Addendum No. 1

RE: Contract ID: C201741
WBS# 1CR.10661.7, 1CR.10661.8
Northampton County
NC-35 From US-158 To SR-1337 and
NC-308 From US-258 To Bertie County Line.

March 20, 2007 Letting

PROJECT NO.	SHEET NO.	TOTAL NO.
1CR.10661.7	2	6
1CR.10661.8

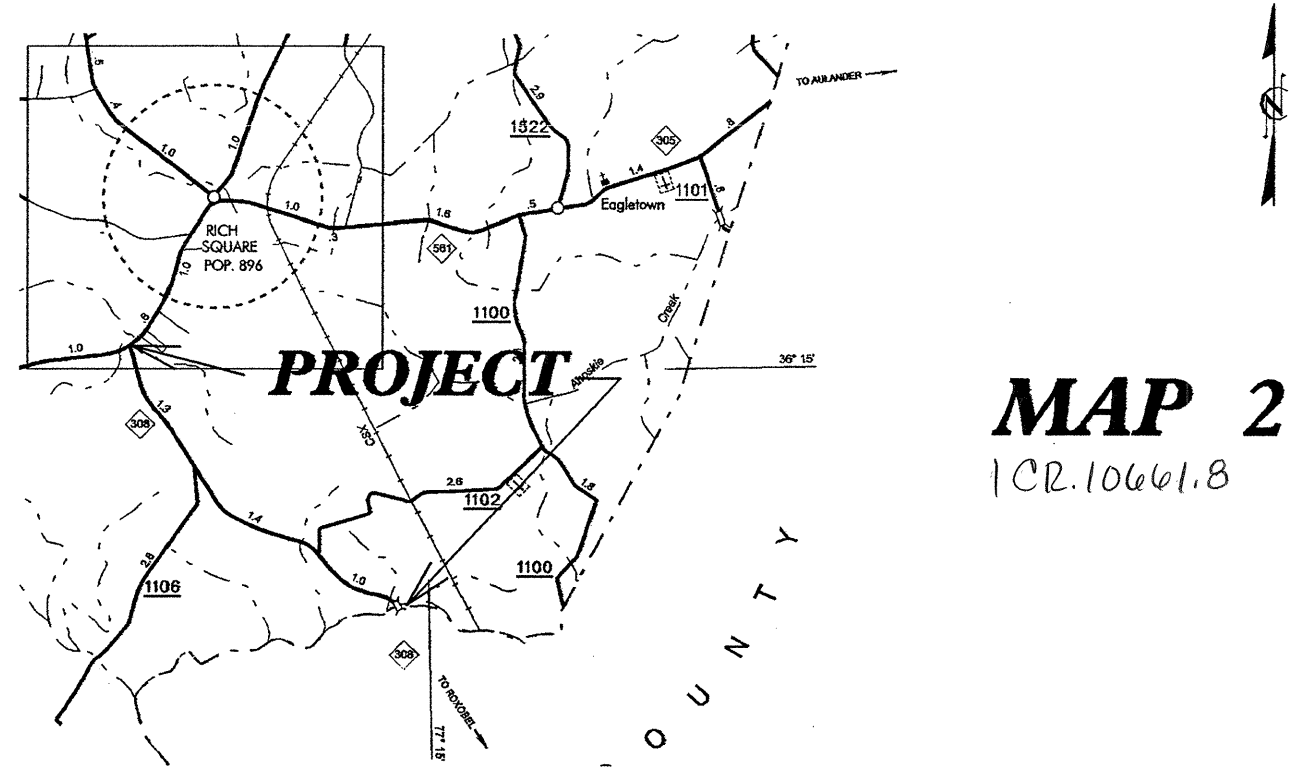
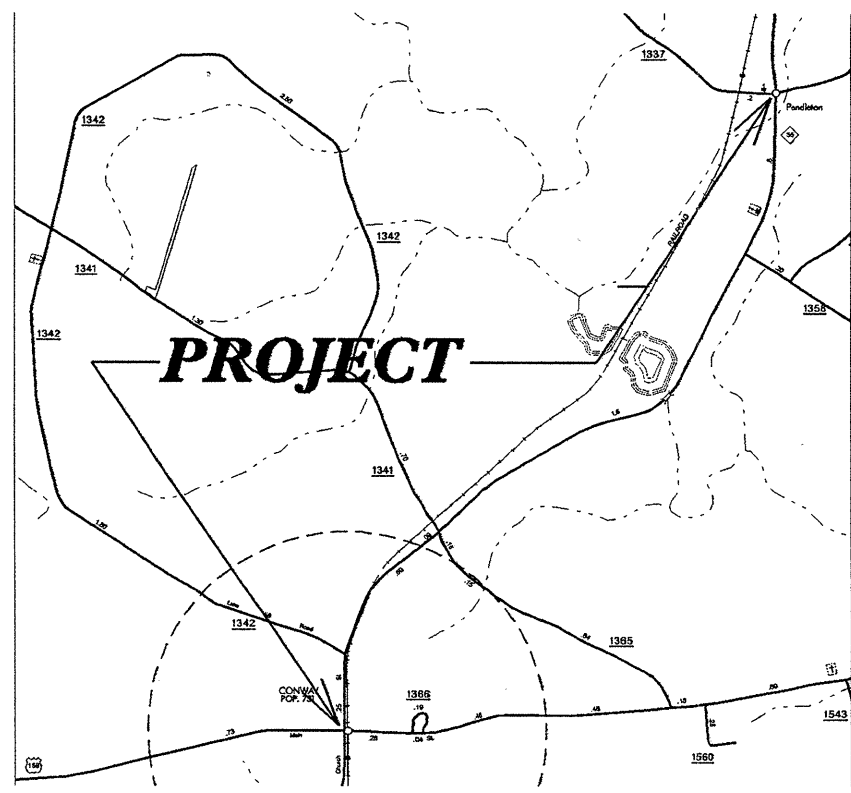
On Sheet No.2, the typical number has been revised for Map no. 2. Please void Sheet No. 2 in your sketch maps and staple the revised Sheet No. 2 thereto.
